Grading &
Drainage
2013075

Project Title: FedEX Ground City Drainage #: _____
DRB#: _____ EPC#: 14EPC-40012 (Project #1009982) Work Order#: _____
Legal Description: A portion of Tract 12, Tract 13, and Tract 14A, Town of Atrisco Grant Unit 5
City Address: Not yet assigned

June 11, 2014

**RE: FEDEX GROUND OVERALL GRADING AND DRAINAGE PLAN
RESPONSE TO COMMENTS**

**OVERALL GRADING
AND DRAINAGE PLAN**

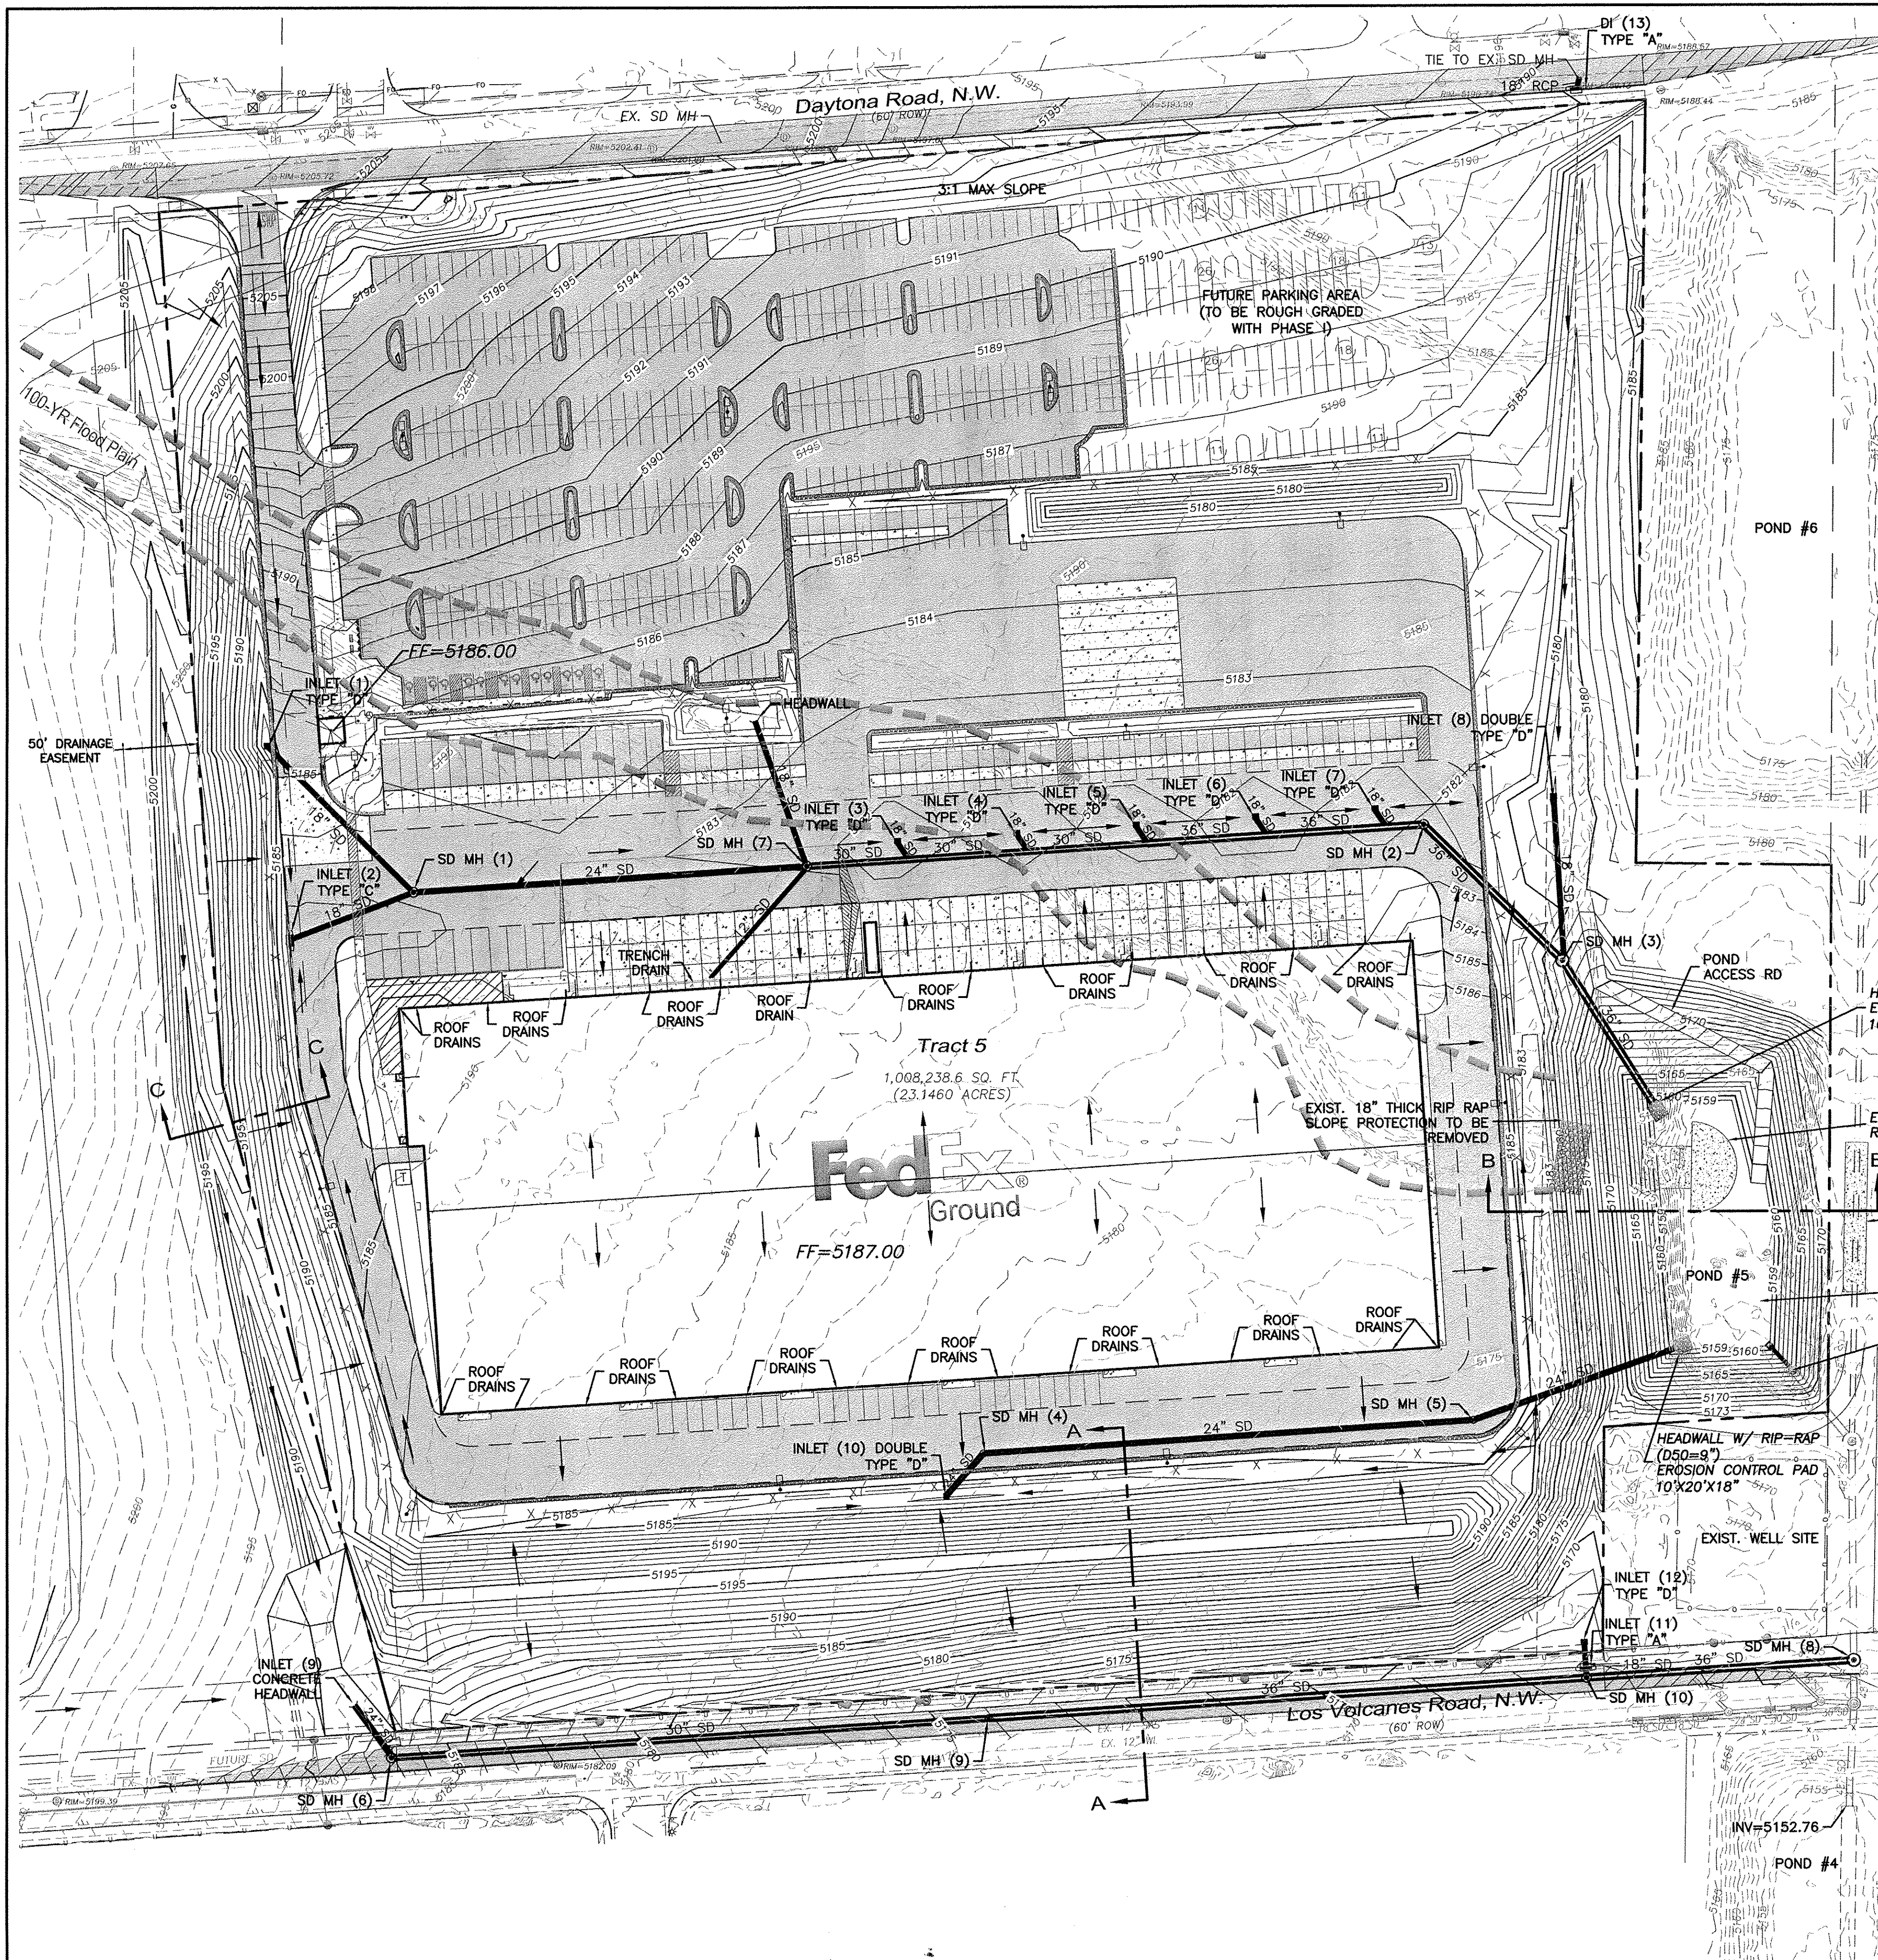
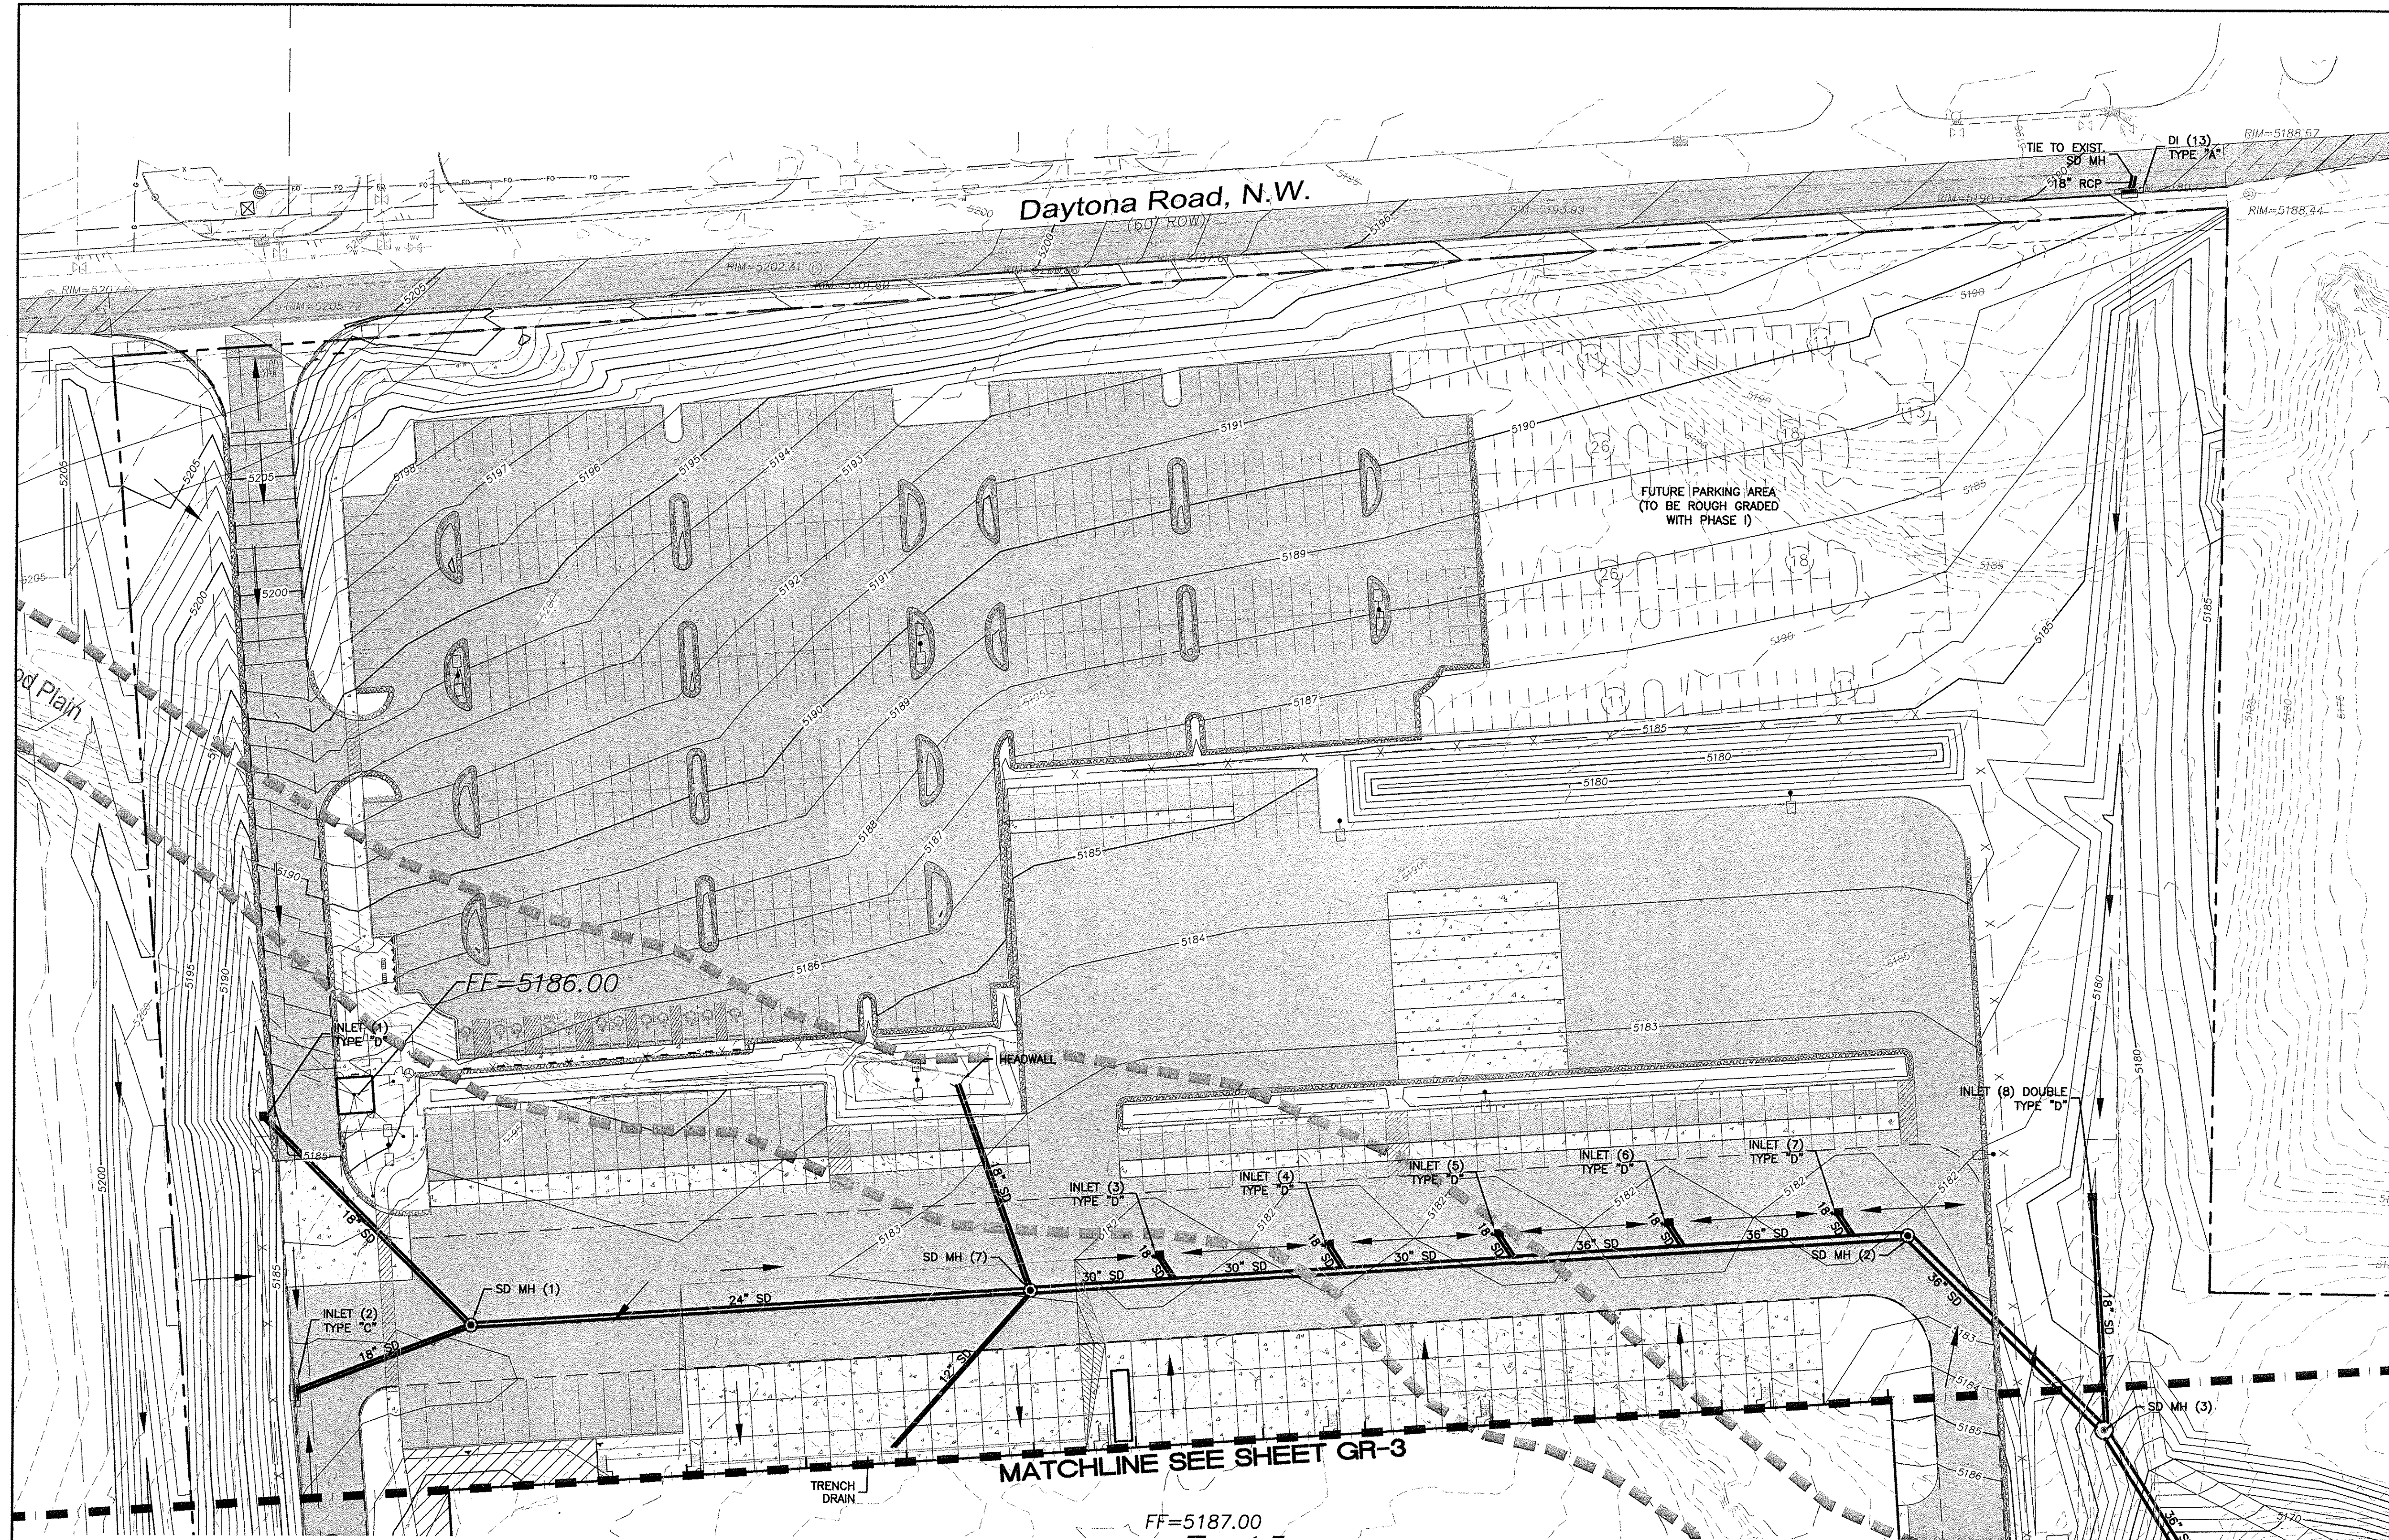
3. Show/state that Pond 5 has the capacity to accept flows from the graded site as Land Treatment C. Rough calculations show that it has capacity.
Pond 5 does have the capacity to accept flows from the graded site under interim conditions for rough grading purposes as well as for ultimate conditions with a fully developed site. The existing pond volume is 4.73 acre-feet. The proposed pond volume is 5.404 acre-feet. The calculated interim runoff for a rough graded site as Land Treatment C is 2.0 acre-feet (see attached Weighted-E spreadsheet).

4. Is Pond 5 to be used for sediment control as part of the SWPPP? If so, will you be plugging the 3-8" pipes?
Yes, Pond 5 will be used in conjunction with proposed BMP's as part of the SWPPP. The existing primary and secondary outfalls will be protected from sediment leaving the ponding area but will not be plugged.
